# Forest Heights Estates STORMWATER MANAGEMENT PLAN

COUNTY OF EL PASO, STATE OF COLORADO  
APRIL 2022

**FOREST HEIGHTS CIRCLE**  
GRADING AND EROSION CONTROL PLAN  
TITLE SHEET

CONSTRUCTION DRAWINGS  
GRADING AND EROSION CONTROL PLAN

FOREST HEIGHTS CIRCLE
GRADING & EROSION CONTROL PLAN
GENERAL NOTES AND EROSION CONTROL DETAILS

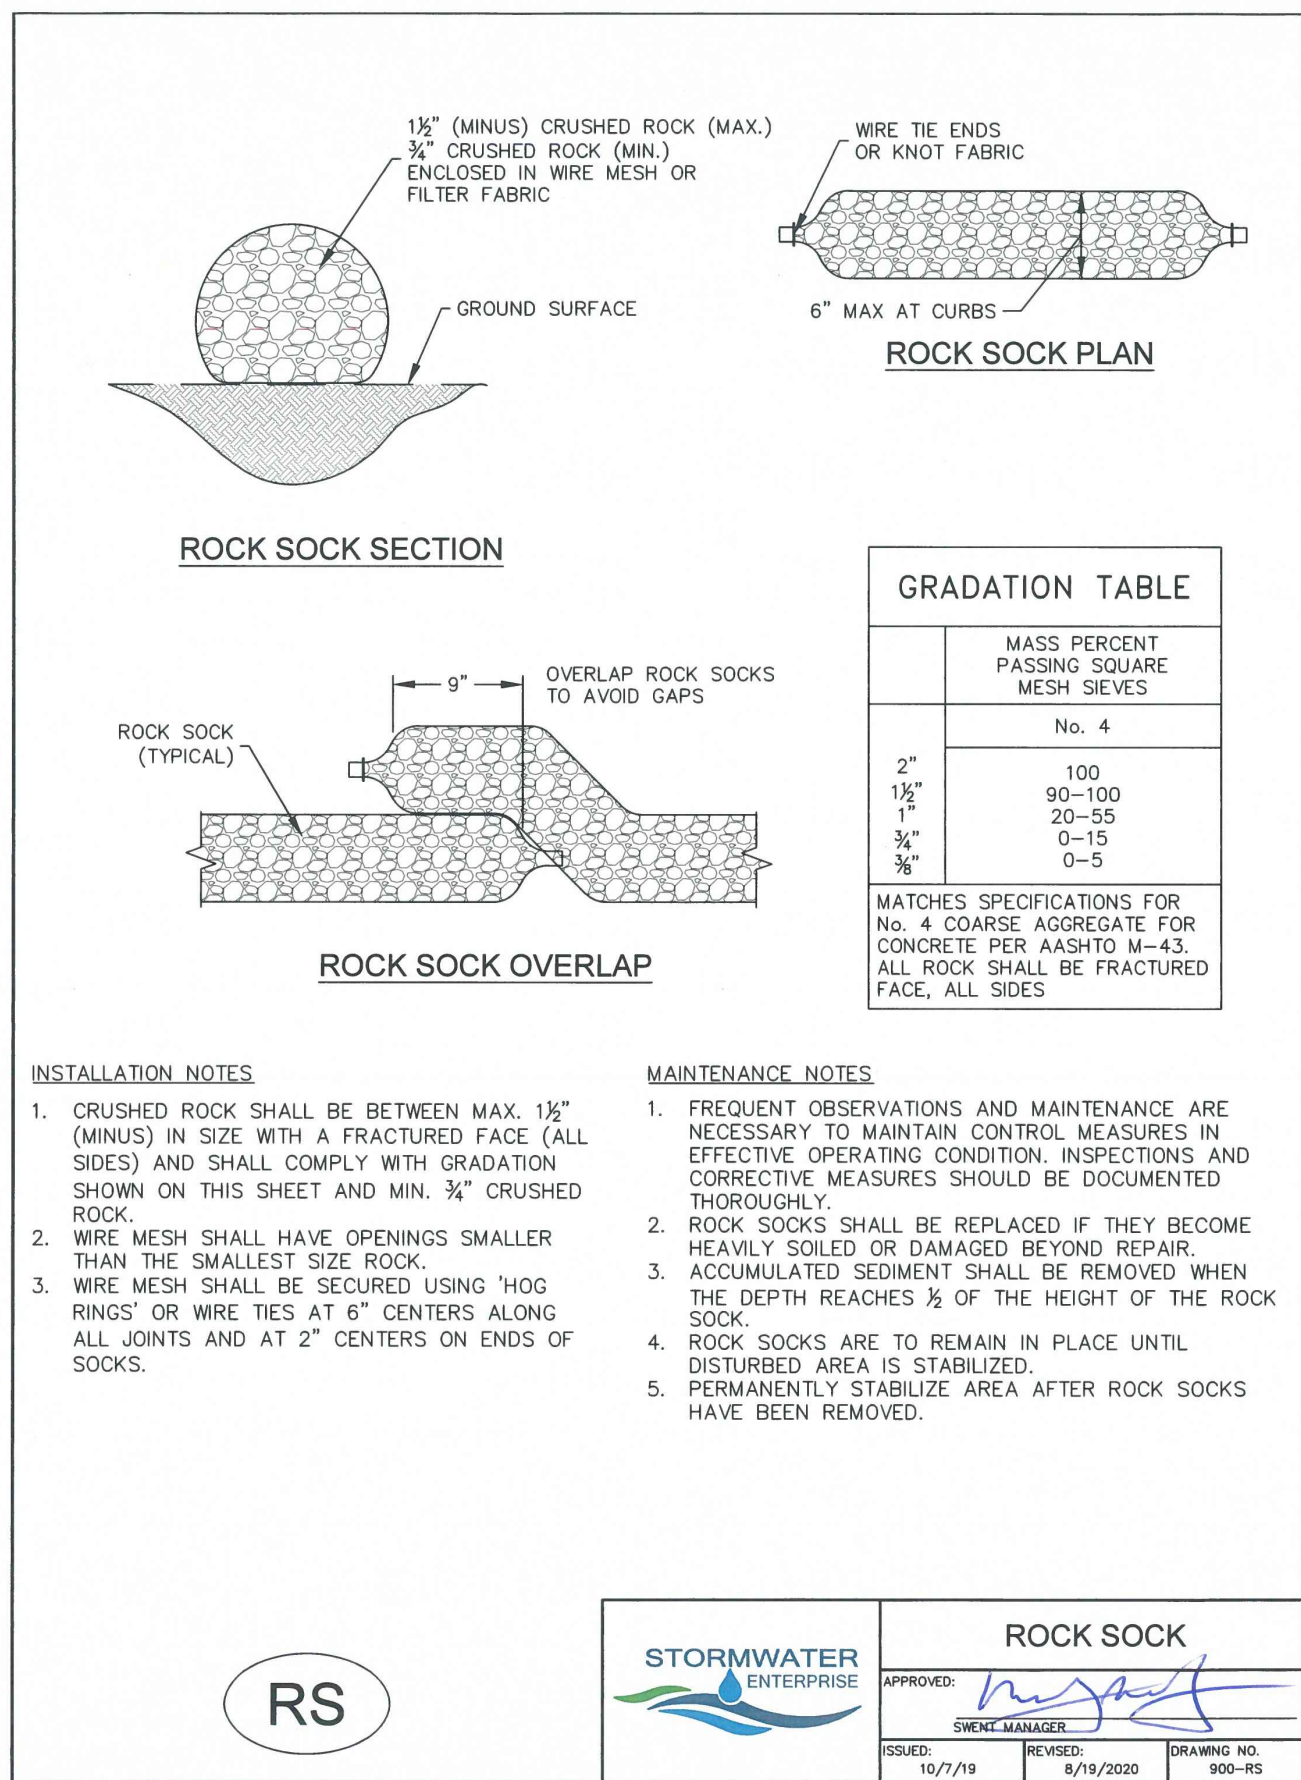
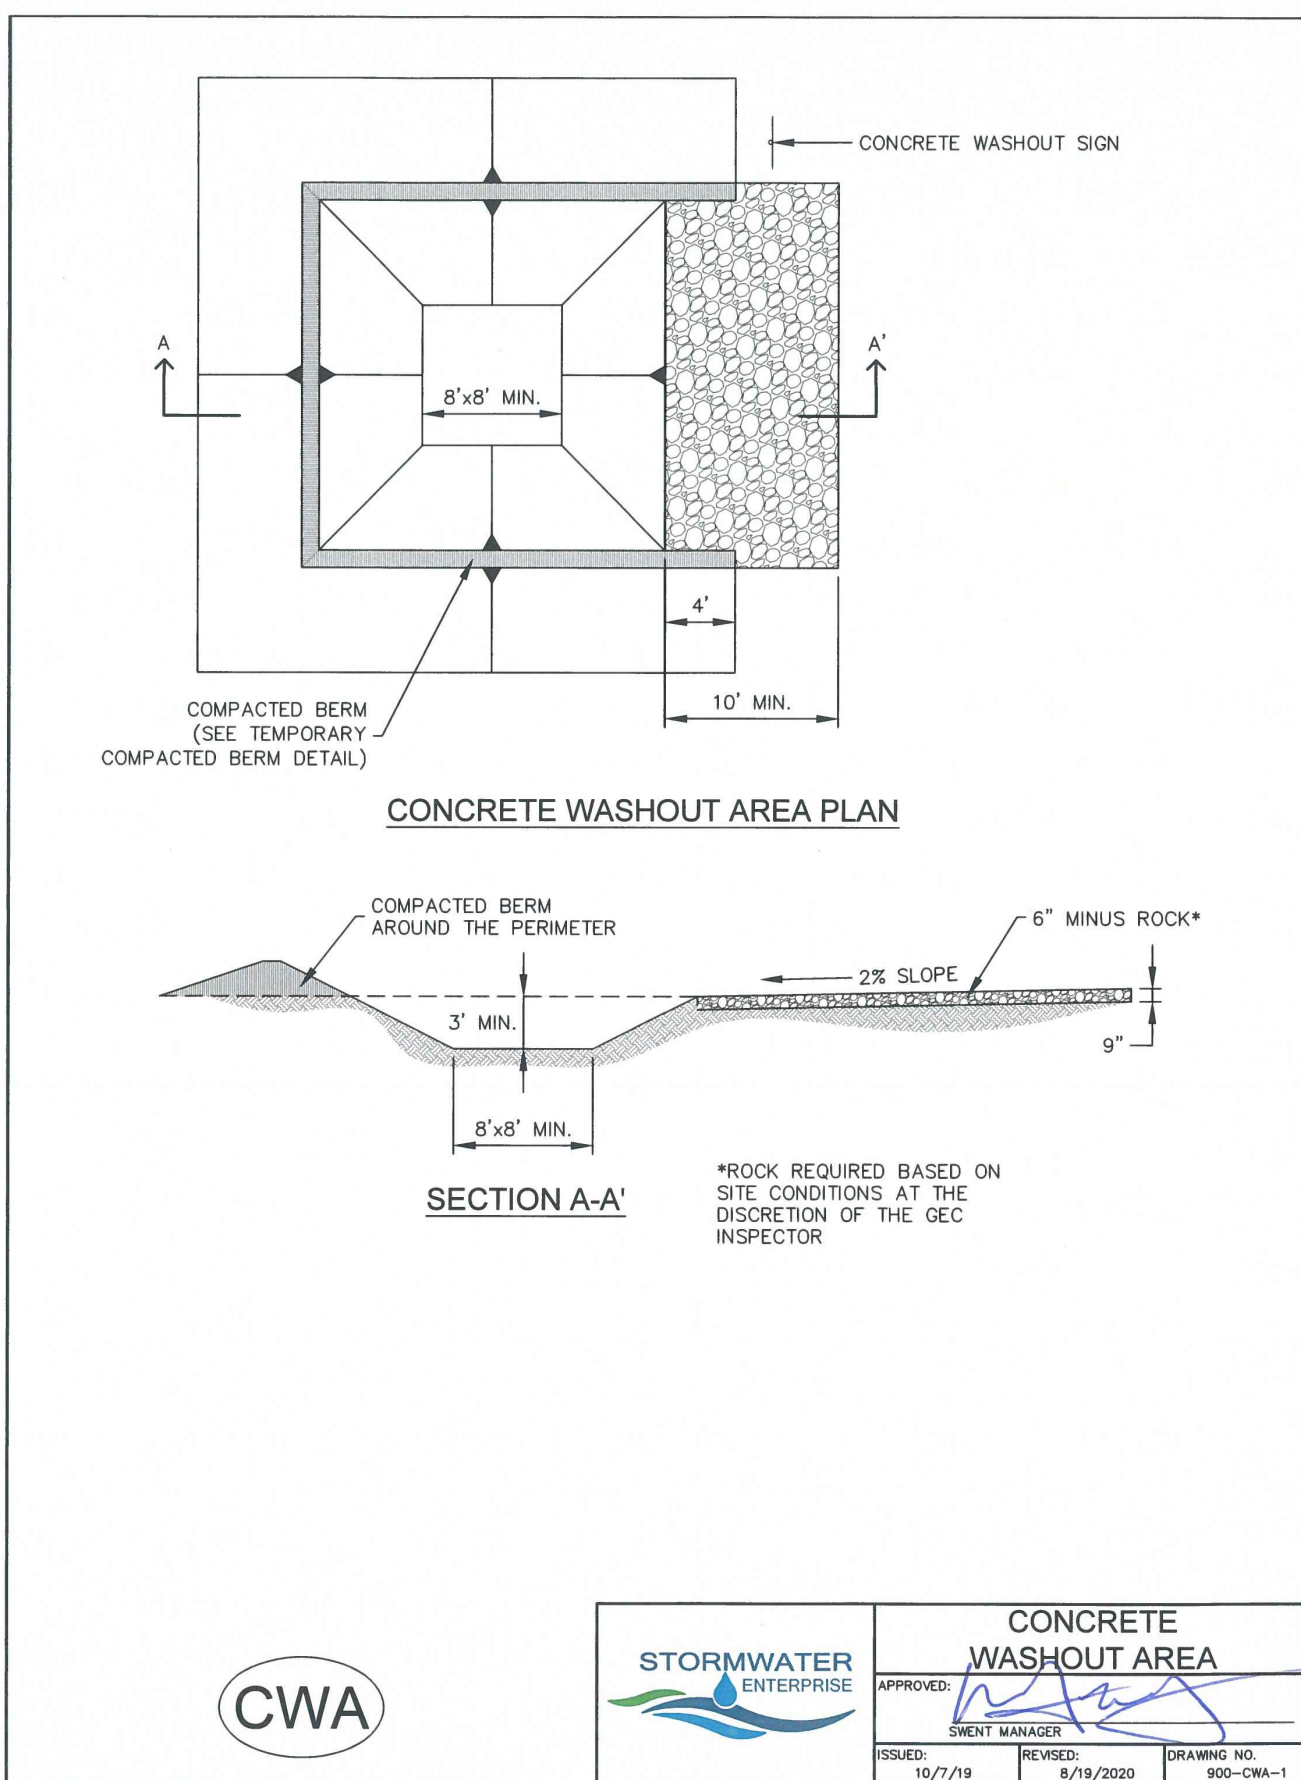
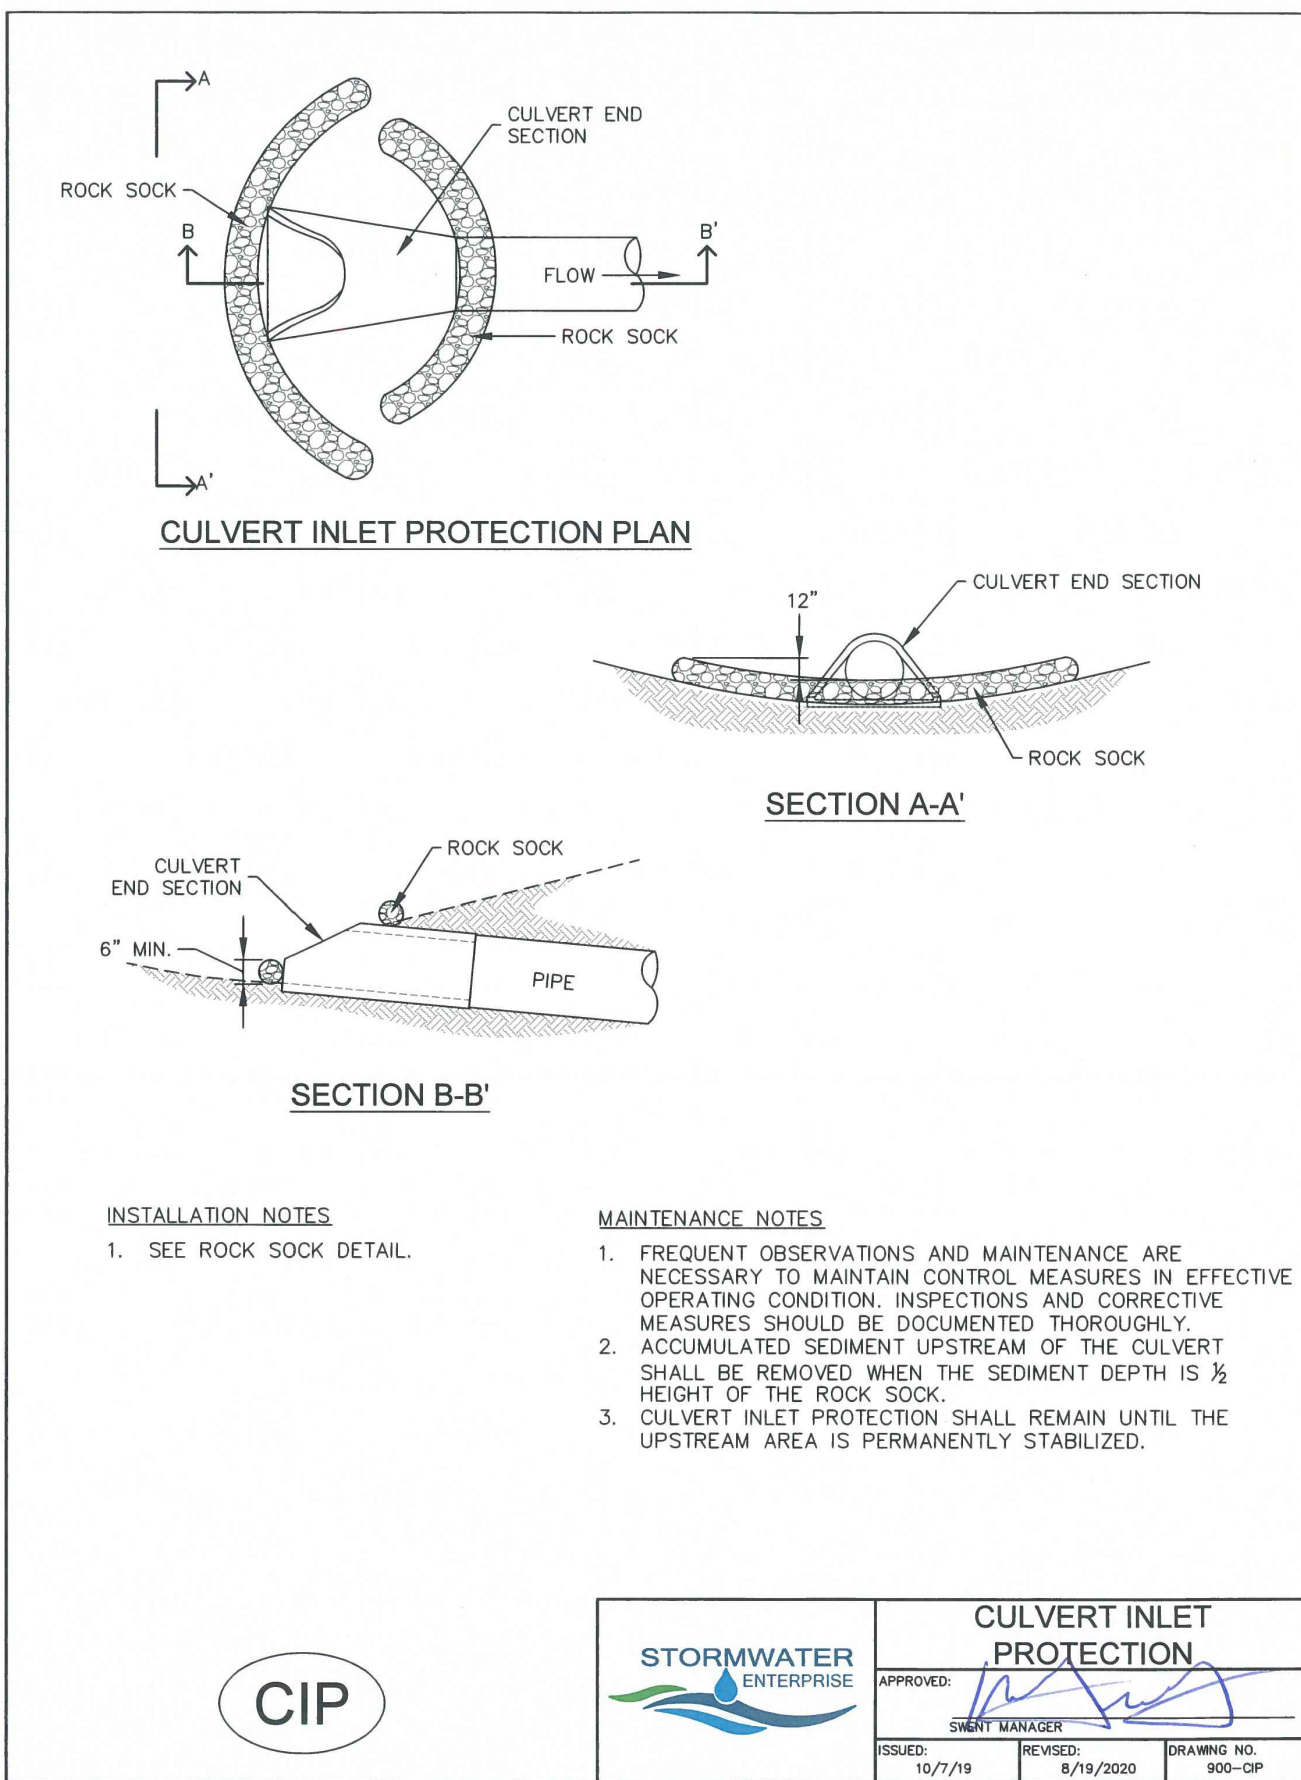
Check dams to be installed a minimum of every 1.5' of vertical fall. Notate spacing and/or include a table for multiple slopes, based on your selected detail, per the example table shown below.

Proposed topo should be shown as black over top of gray existing topo. The only topo shown on this drawing is gray. It is unclear if this is existing or proposed topo. The linetypes currently being used for existing vs proposed contours are almost impossible to follow with so much other gray hatching through the plans.

And show some of the surrounding topo outside the limits of the project so you can show how proposed topo ties into existing topo. There is publicly available county lidar topo if you need it.

If a VTC is added to the plans above, add a VTC detail to this sheet. And make sure to use a EPC approved VTC detail (VT-1 and VT-2 in DCMv2, Chap 3.3) or revise other detail (which usually have 50ft length) to be 75ft min length.
